DECISION DELEGATED TO DEVELOPMENT MANAGER

Application No: H16-0419-21 **Applicant:** Mr & Mrs Jeffery

Proposal: Two storey extension and alterations - approved under H16-0812-20. Modification of Condition 2 to allow amendments to previously approved plans

Location: Willowgate Cottage 2 The Parkway Spalding

Front Elevation
PROPOSED Elevations 1:100

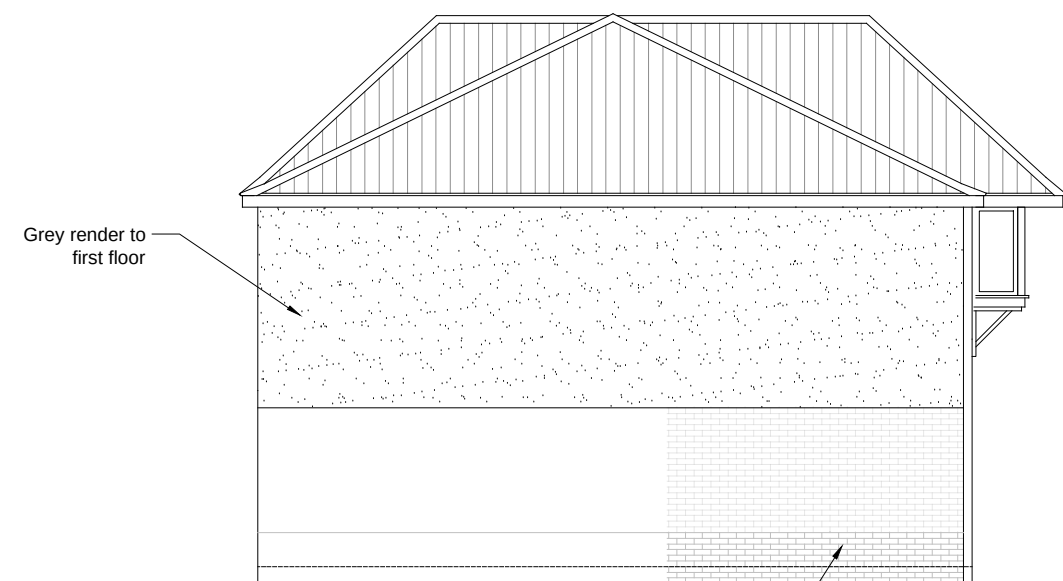
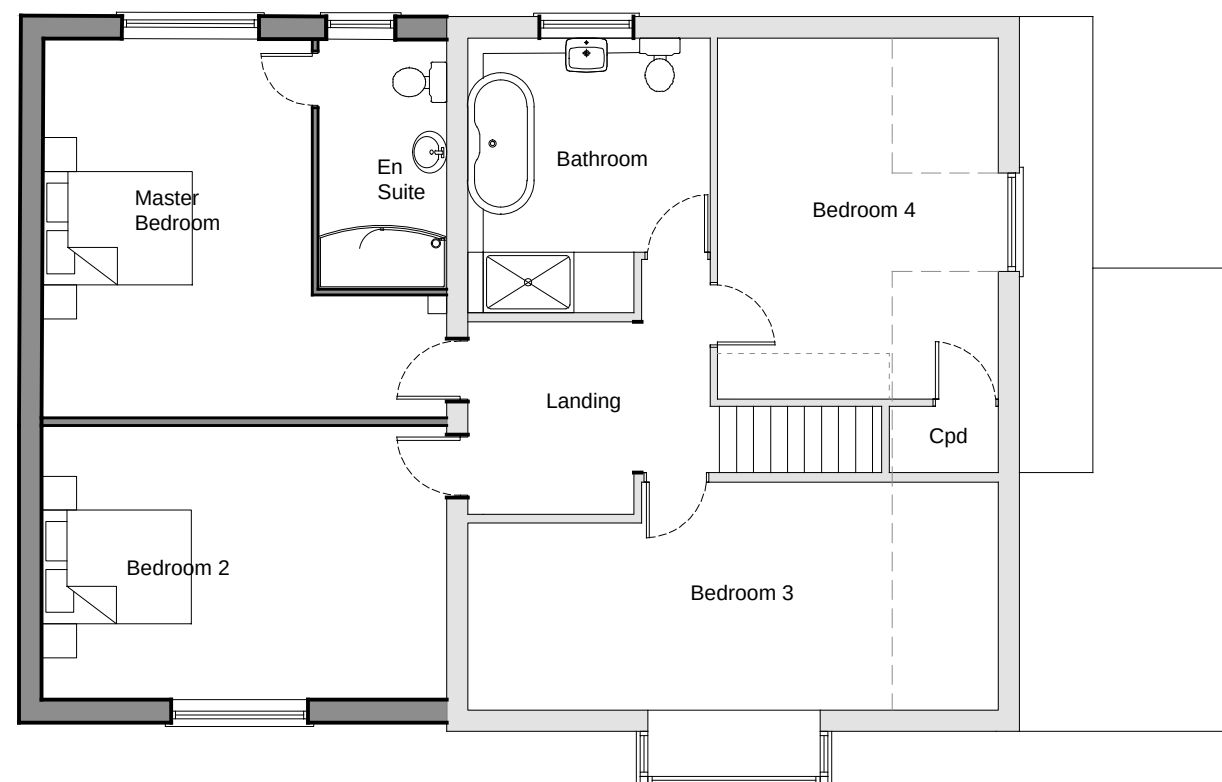
The aim of this modification is to lower the roof height of the extension previously permitted.

The proposed reduction in the roof height is considered to result in an overall better design which is more sympathetic to the existing house and not overly prominent in comparison to the existing roof design.

The proposed amendment would result in a lesser impact on neighbouring amenity compared to the previously approved scheme and therefore complies with Policies 2 and 3 of SELLP (2019).
